SSD 6626 - SICEEP Darling Square - Mixed Use Residential Building within North-East Plot

Submission by:

21 November 2014

SSD 6626 Submission

SICEEP - SSDA7 Shadow Study

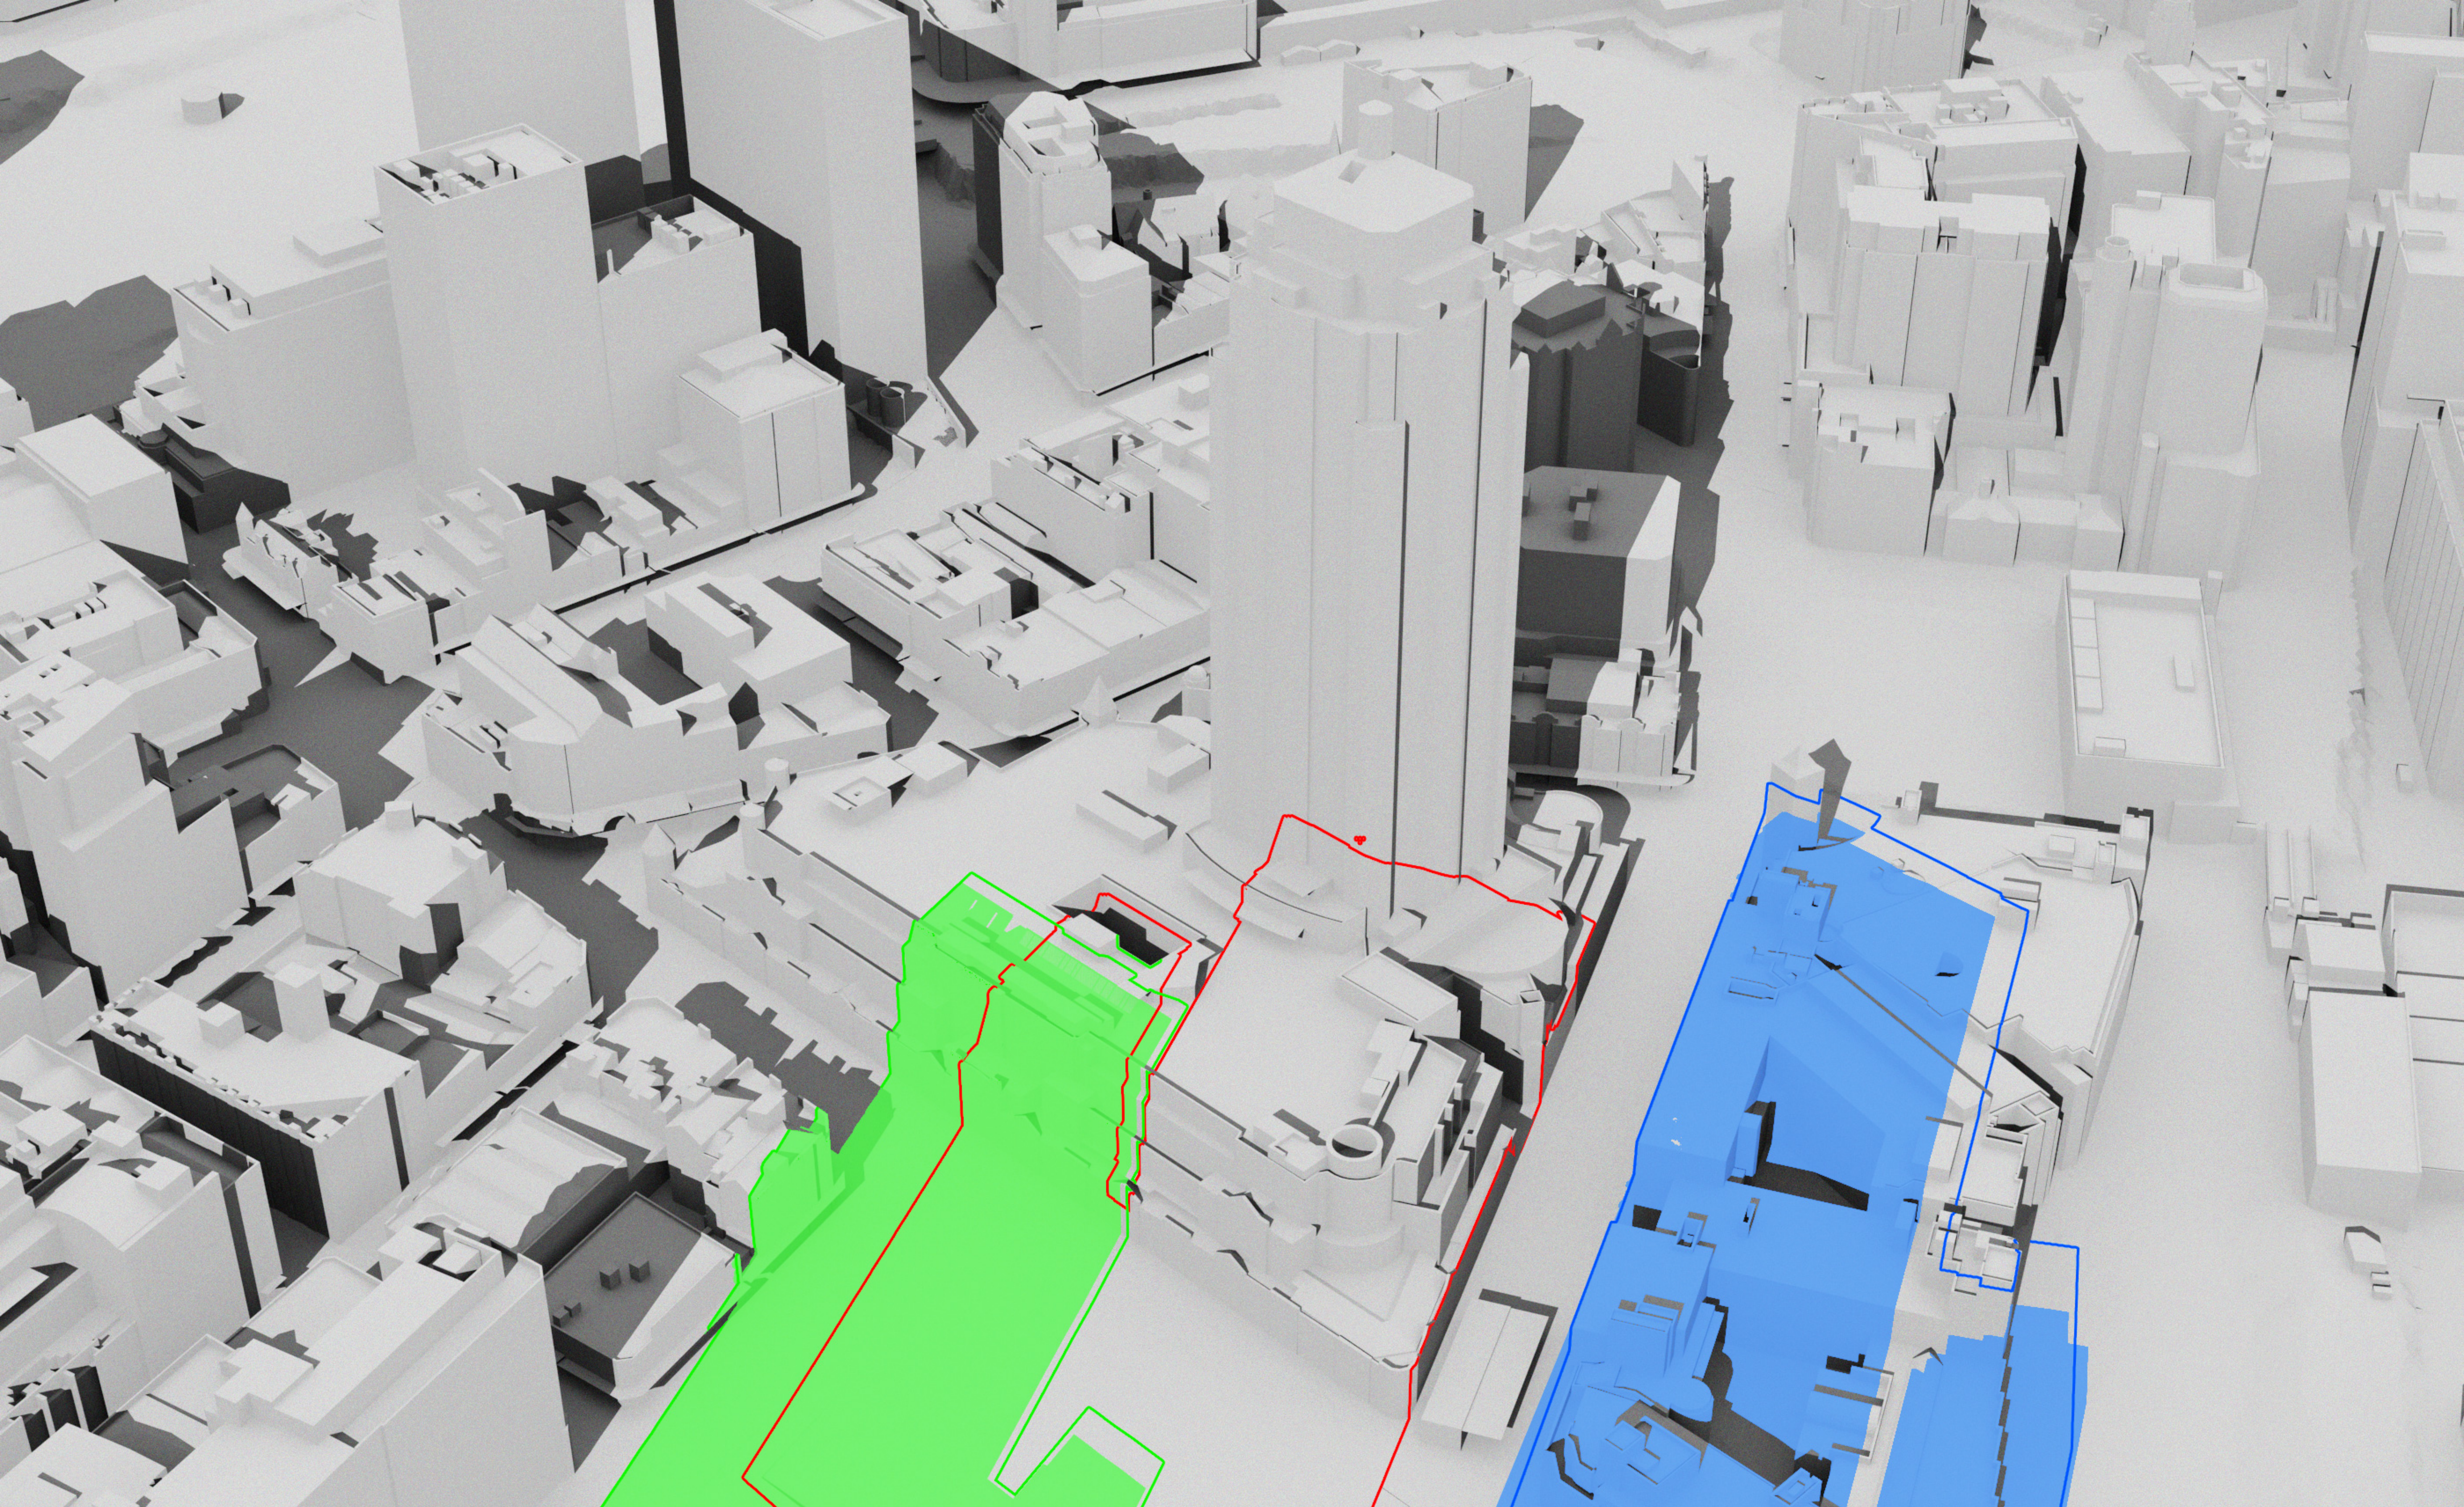
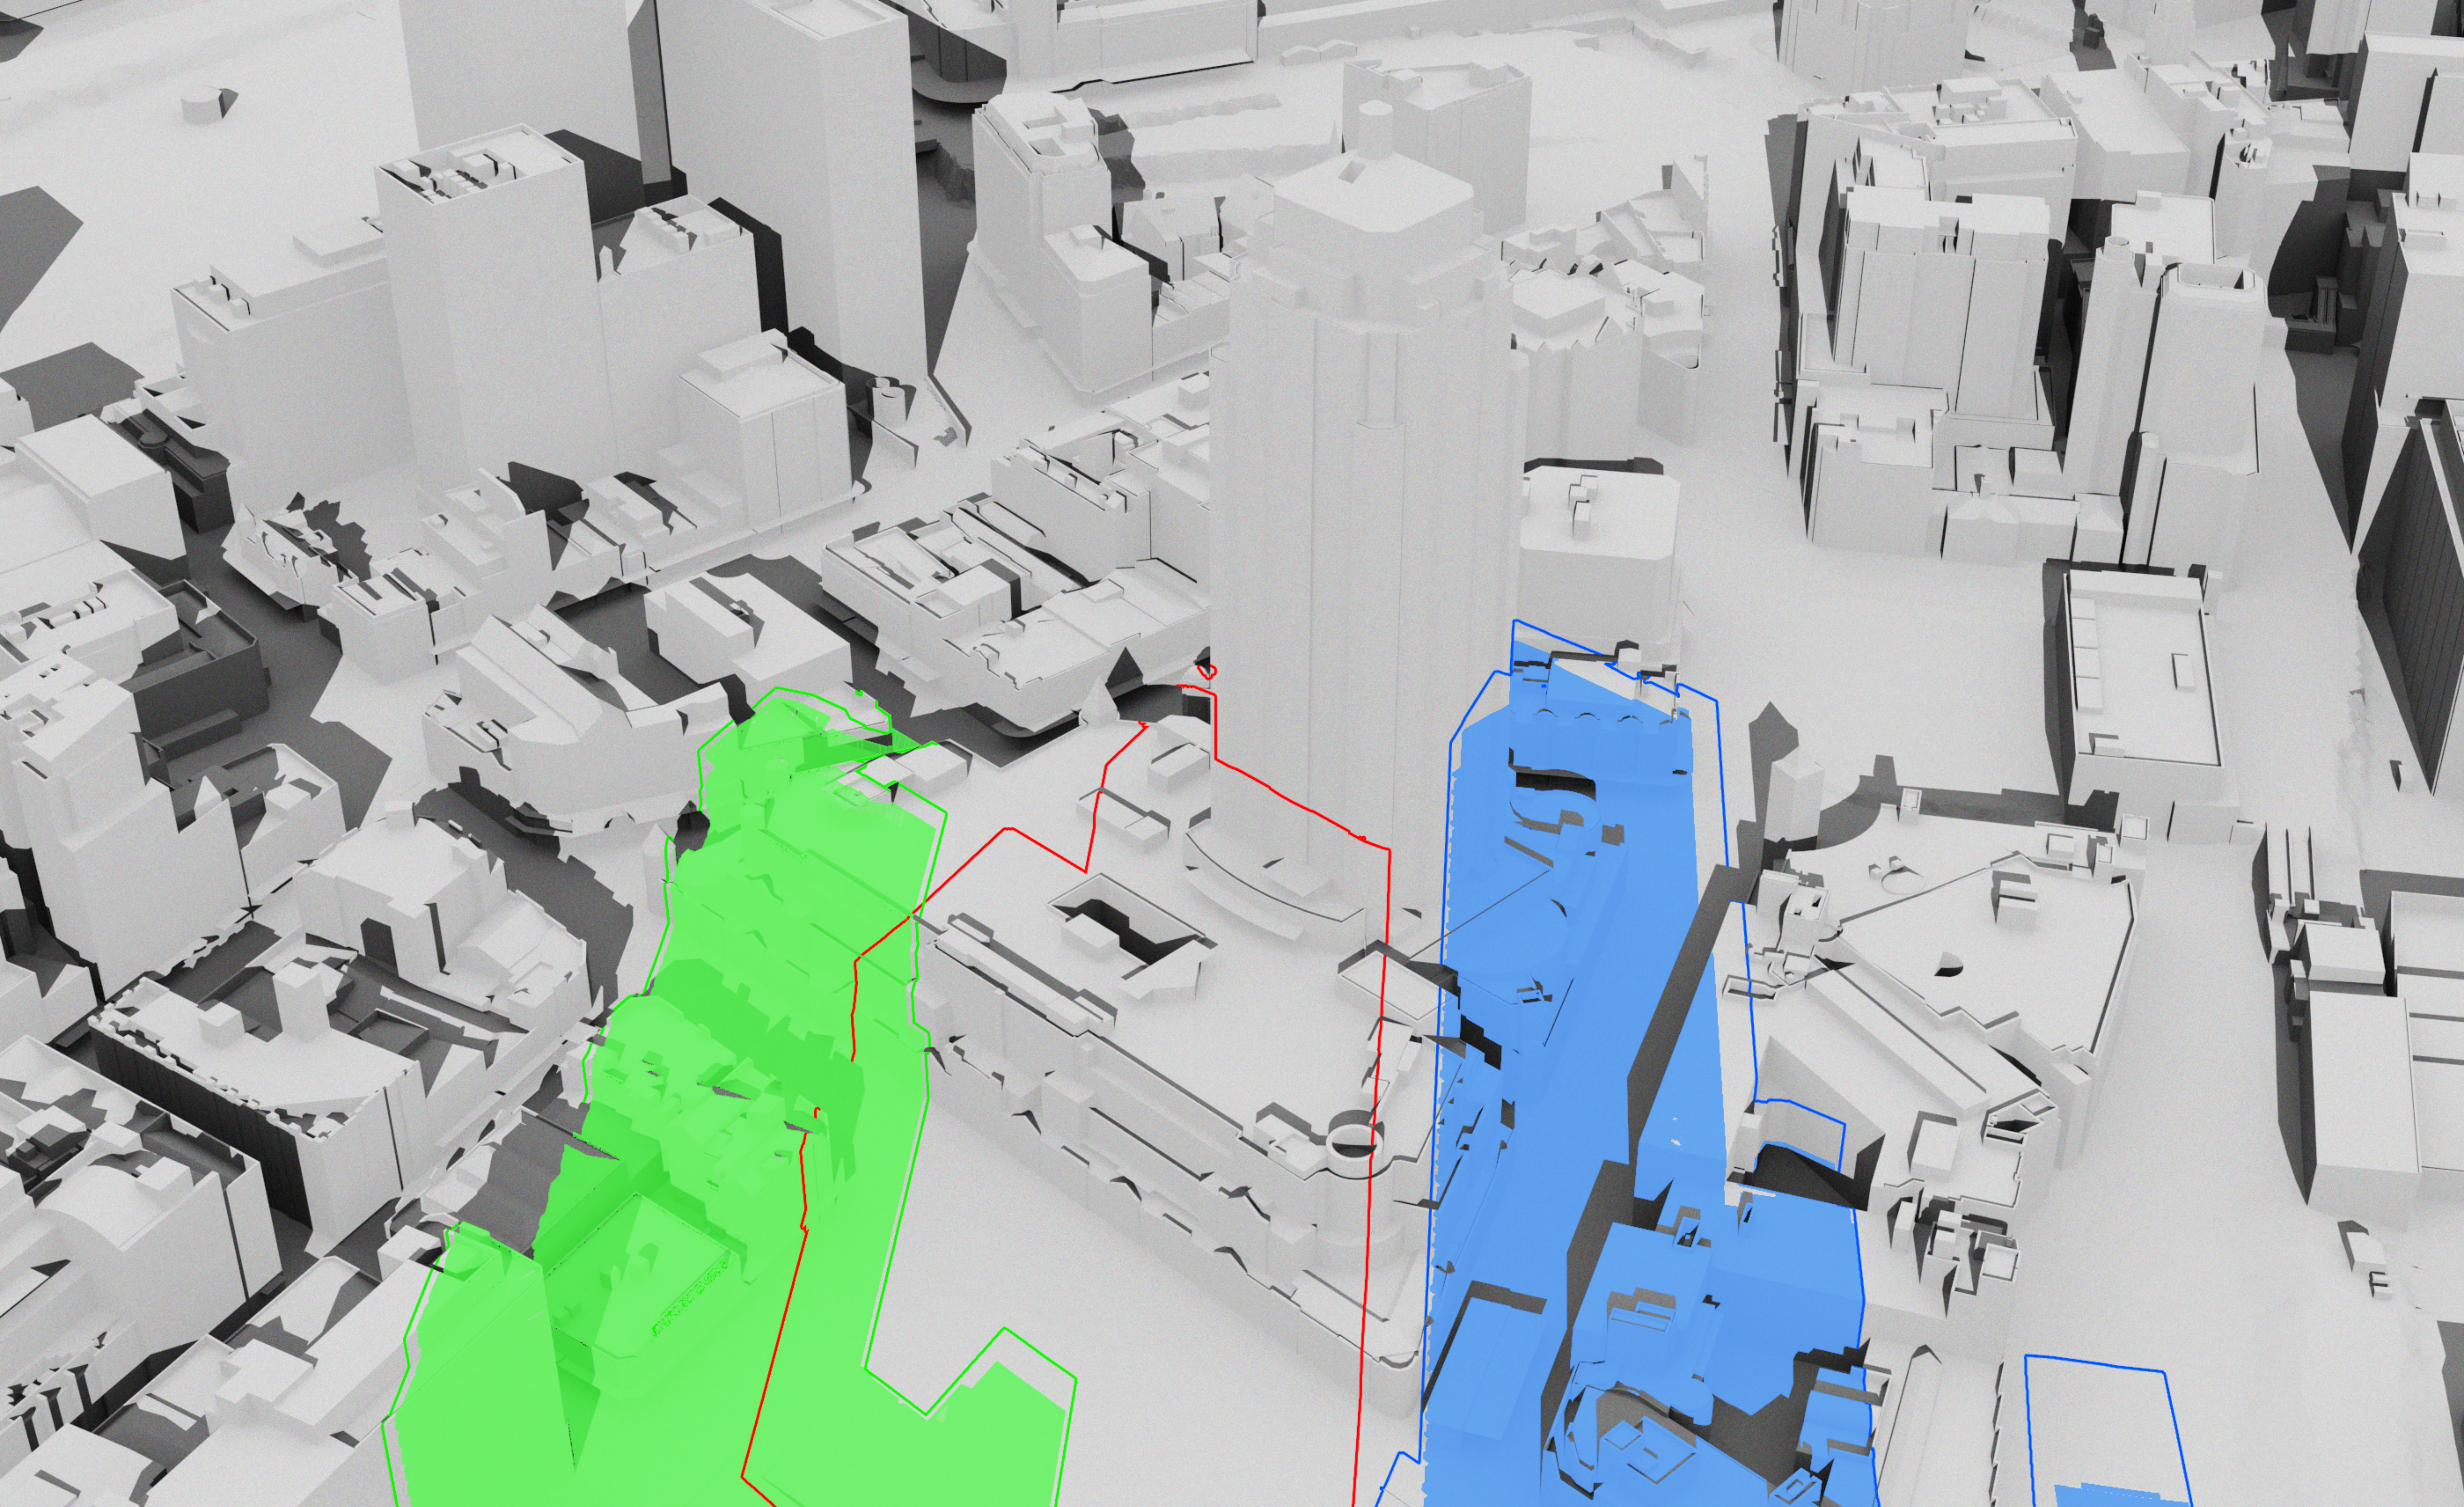
With respect to the podium of The Peak Apartments, the EIS states that " The landscaped podium associated with The Peak Apartments will continue to receive at least two hours of solar access, ensuring compliance with the intent of the Sydney DCP 2012.". Although this statement is true, two hours is a major reduction from the existing 21 June daylight access of about six hours.

Excessive overshadowing of public open space - the new square - "Haymarket Square"

We agree with the City of Sydney's view that "excessive morning shadows are cast into the outdoor and café areas in the new square by new surrounding building edges. In order to improve morning sun access to the square in winter, it is recommended that the building heights lining the new square be reduced and the floor area relocated to the surrounding streets podium edges..." Source: City of Sydney, SSD 5878 (SICEEP)The Haymarket submission, page 34.
